Reference No: **2025/NM/92956/E**

Site Address: 65-67, Huddersfield Road, Shelley, Huddersfield, HD8
8HG

Description: Non material amendment to previous permission
2023/93480 for erection of ground floor and first floor
extensions and alterations to convert two dwellings
into one dwelling

DECISION – REFUSE NON MATERIAL AMENDMENT

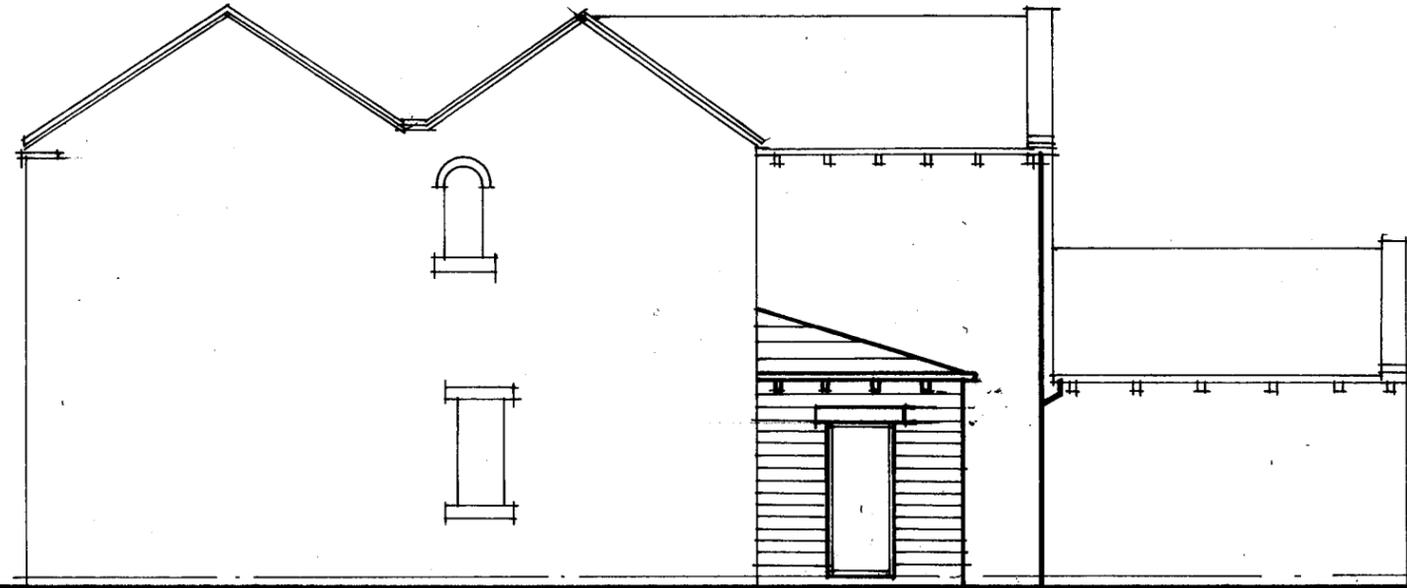
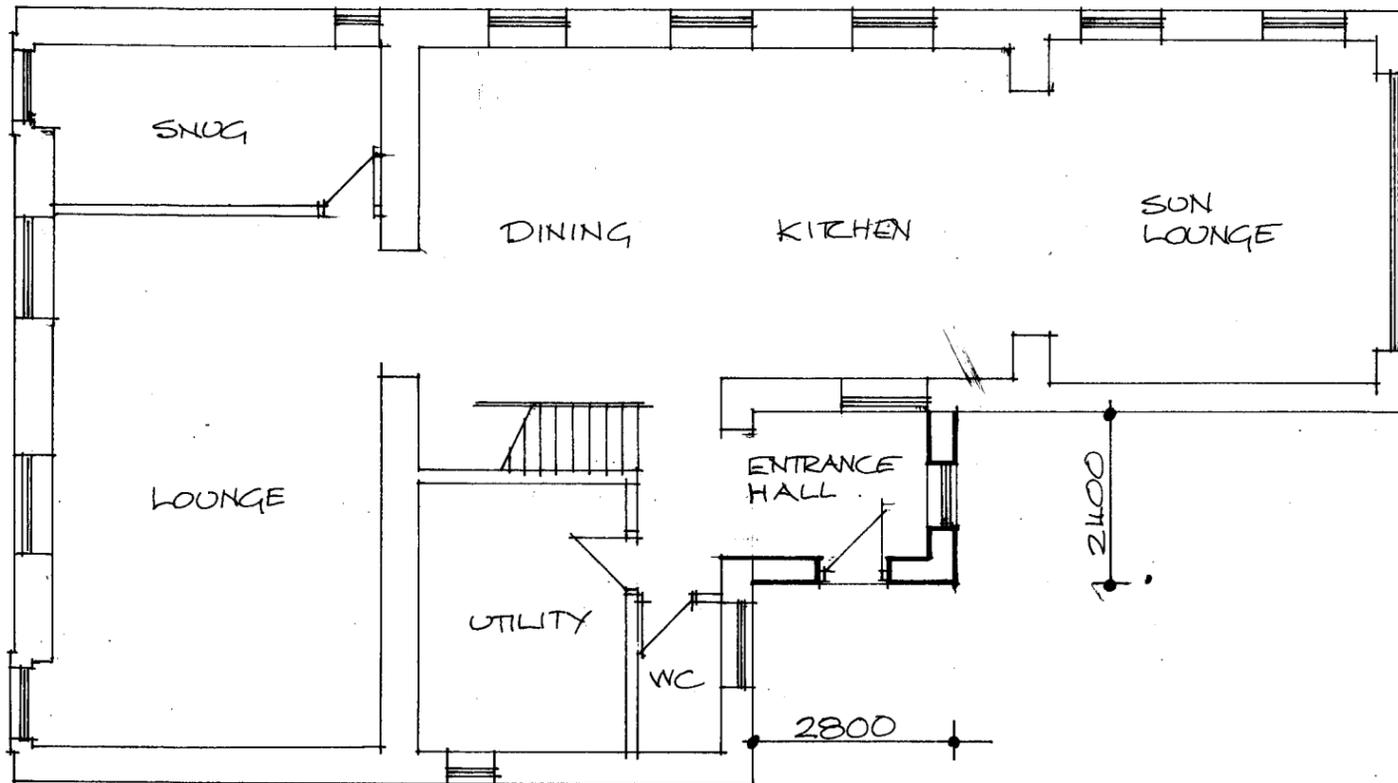
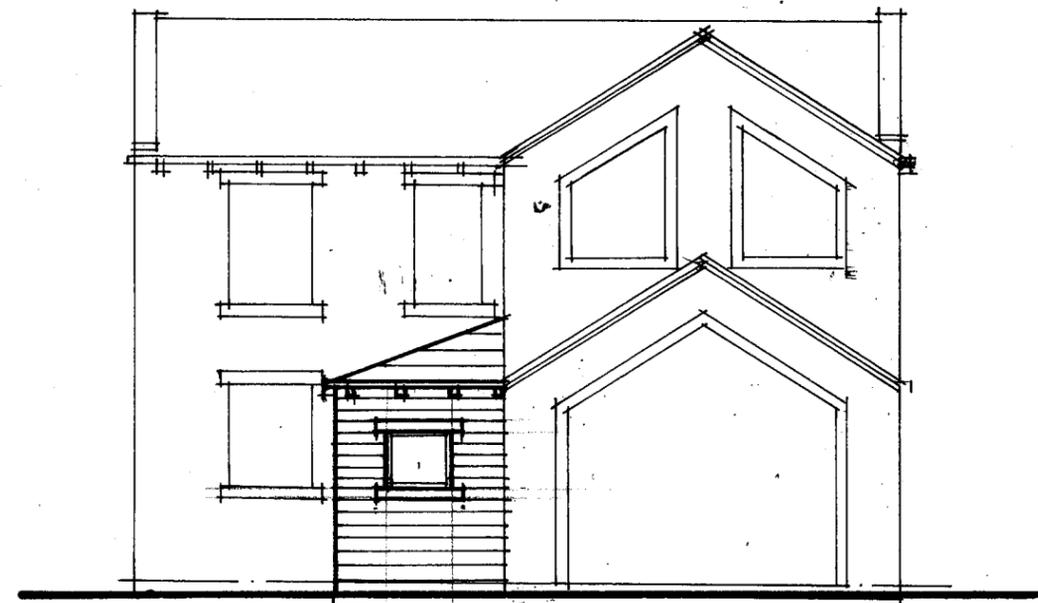
The proposed entrance porch would project 2.8 metres from the rear elevation of the building with a width of 2.4 meter. The eaves height would be 3 metres with an overall height of 3.8 metres to the ridge of the lean-to roof. Submitted drawing HRS/09 is annotated and states that the walls would be constructed from stone with feature detailing to match the existing with a stone slate roof that would also match the existing.

The proposal would result in an increase in the built form of development previously approved being increased in scale, magnitude and degree. The approved plans demonstrated a canopy to the rear elevation in the form of a pitched roof on posts with the amendment proposed resulting in a solid structure by way of a single storey lean-to extension to create a solid structure to accommodate a porch. Therefore, the change is considered to be consequential in relation to the original approval as the built form of development would have an altered visual appearance to that approved both in terms of size, scale and the construction of walls and an altered roof form.

There are openings proposed within the side elevation of the porch which would face neighbouring properties and therefore, a third party could be affected or be disadvantaged by the proposal. Notwithstanding this, the resultant accommodation would be non-habitable and therefore not considered to cause significant undue harm as a result of the additional openings.

Comment – the proposed change would result in change to the approved built form of development. The approved canopy which is set upon posts would be replaced by a solid structure in the form of a single storey lean-to extension to accommodate a porch. As such, the proposed amendment cannot be considered as a non-material amendment.

The amendment sought to replace the rear extension canopy with a single storey extension to form a porch as shown on drawing number HRS/09 is not considered appropriate to be regarded as a non-material amendment to the previous planning approval 2023/93480. The applicant is therefore advised to submit an application to vary Condition 2 (approved plans) under a Section 73 (variation of conditions) application for the proposed amendment.
